Re : Planning application AW/353/14PL – 11 Marquis Way, Bognor Regis, PO21 4AT

I am writing to object to the proposal to demolish and rebuild No. 11 Marquis Way. My objections are set out below.

project: 11 Marquis Way - Aldwick			
drawing title: Proposed Site Plan			
drawing status: Planning Application			
date: 09 - 12 - 2014	scale at relevant drawing size 1 : 50 (A1) or 1 : 100 (A3)	no: JW131105 - PL10	rev.: -

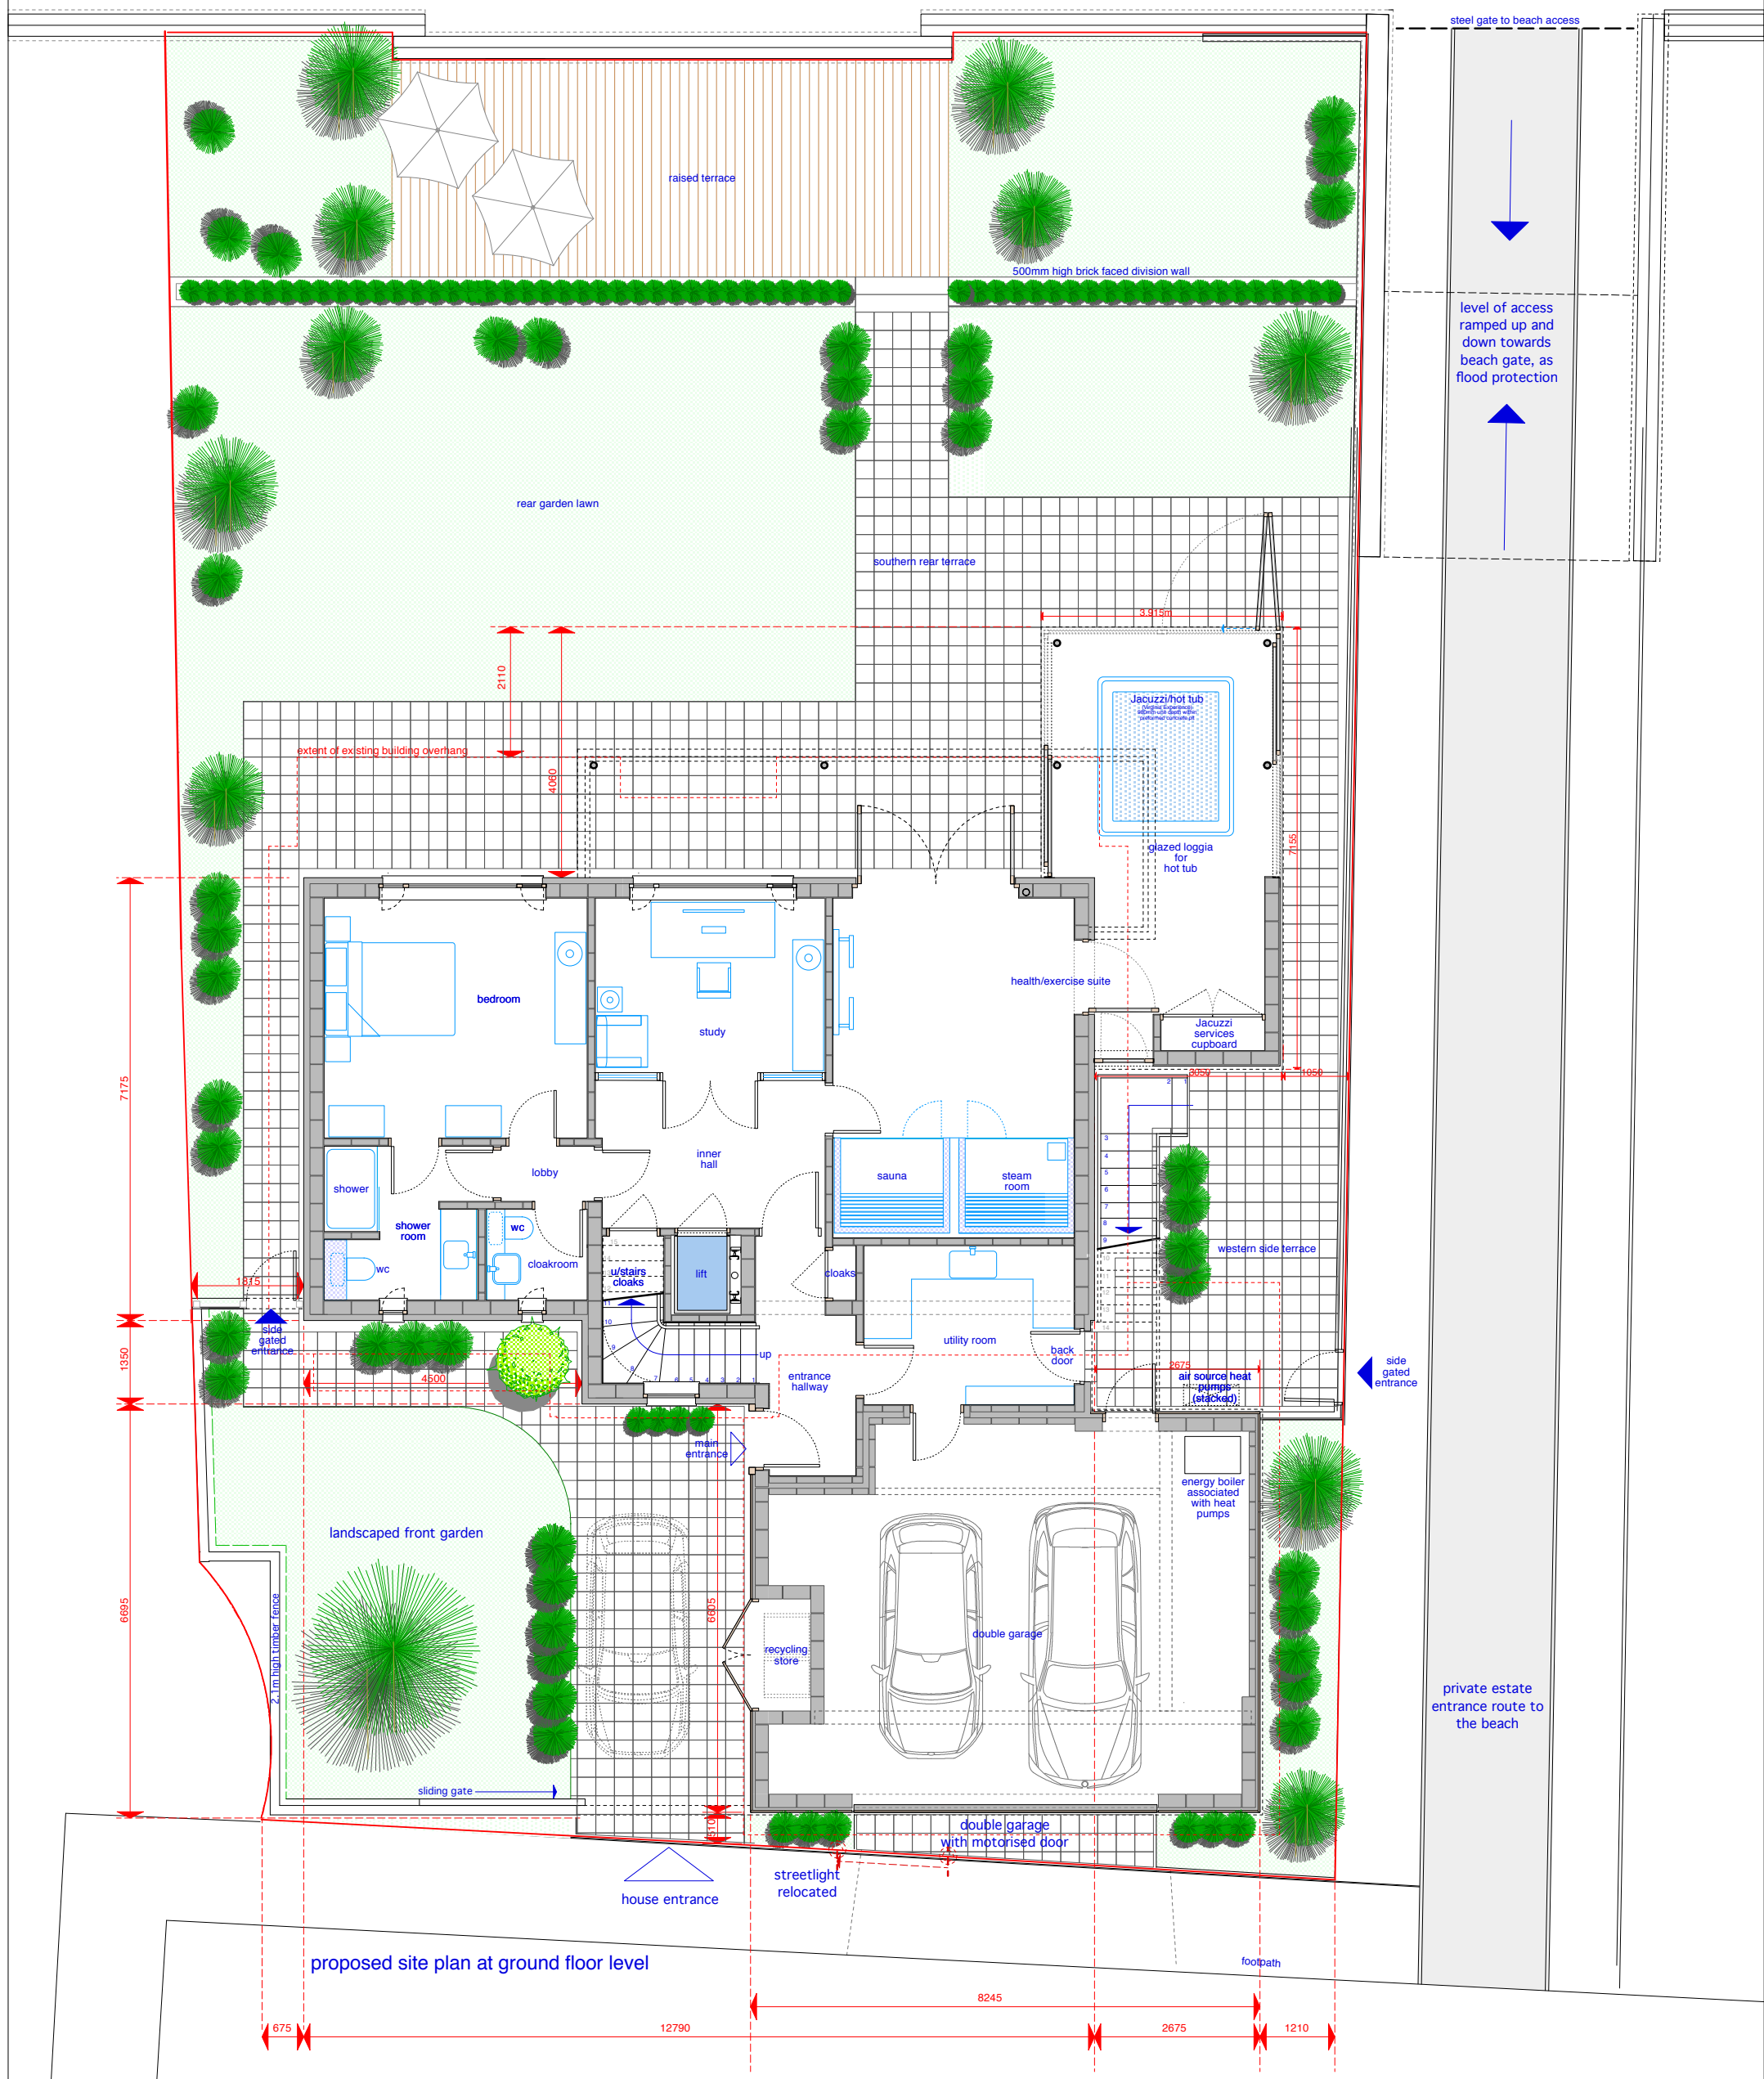
Planning History. Conditions have been imposed on previous planning applications for buildings on Marquis Way requiring that they "match the colour and texture of those existing buildings" (AW/200/10). The proposed development clearly does not match. The proposed development also breaches the current building line, a restriction that has been enforced when planning approval was granted for No. 15.

project:	11 Marquis Way - Aldwick		
drawing title:	Proposed Sections A and B		
drawing status:	Planning Application		
date:	scale at relevant drawing size	no:	rev:
09 - 12 - 2014	1 : 50 (A1) or 1 : 100 (A3)	JW131105 - PL19	-

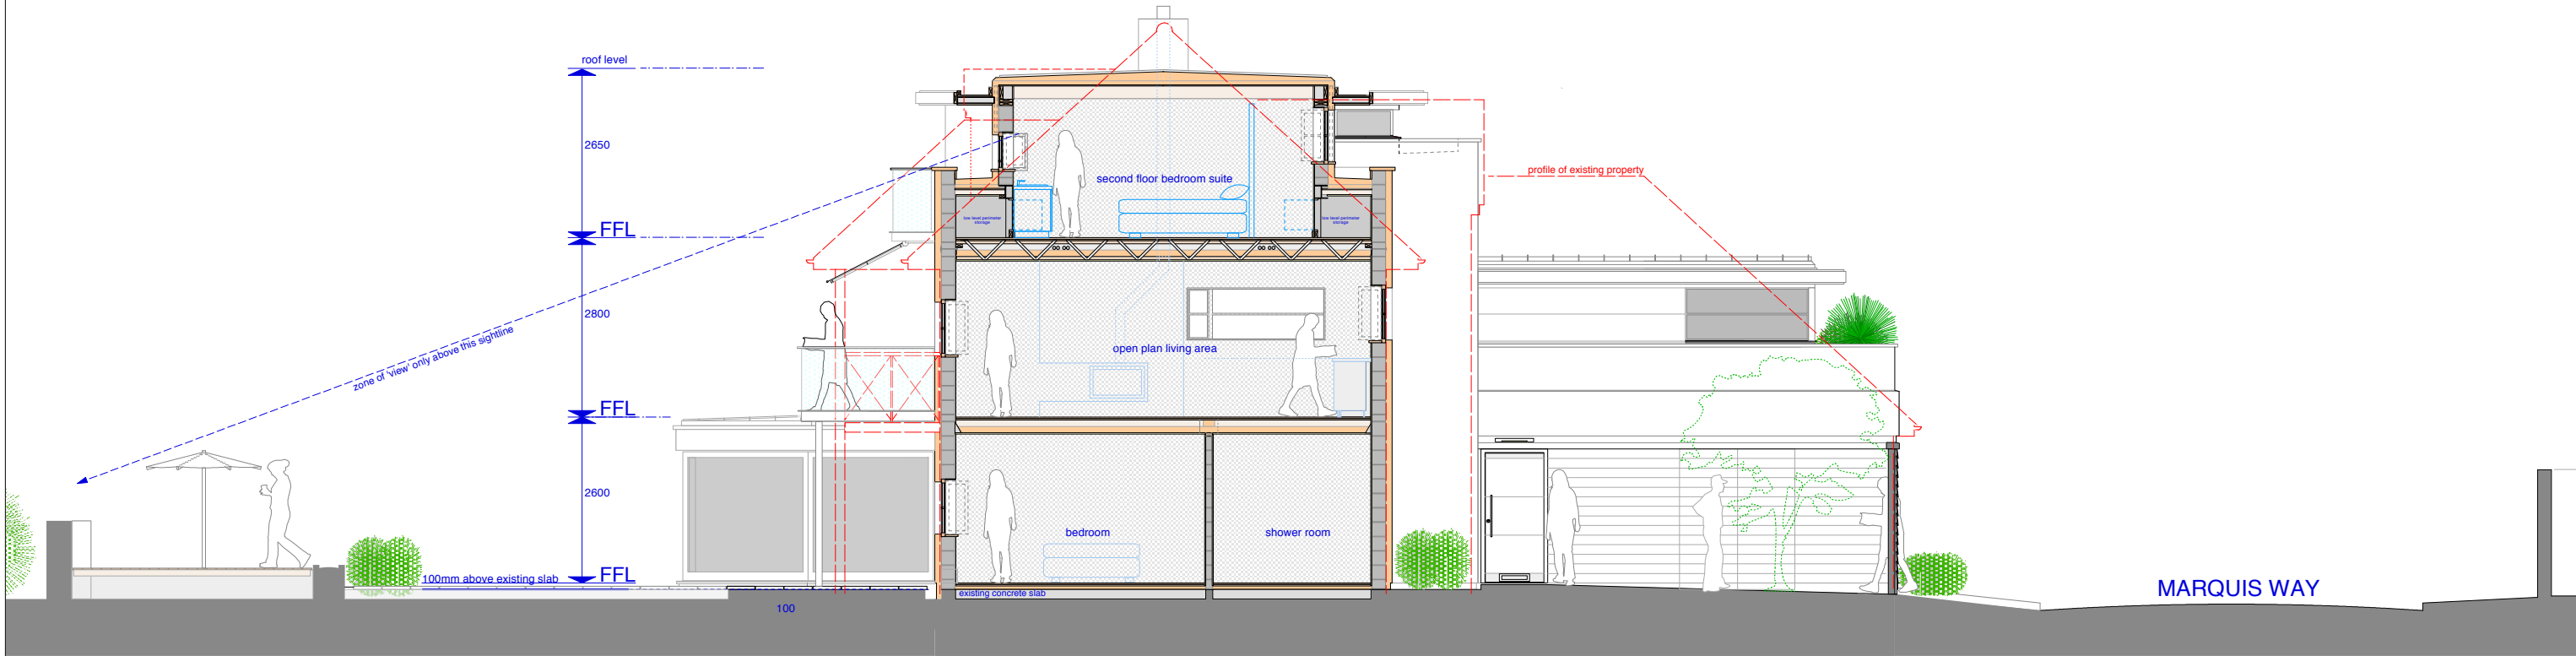
Privacy of existing properties. Several properties that are not currently overlooked will become overlooked as a result of the proposed development (balconies).
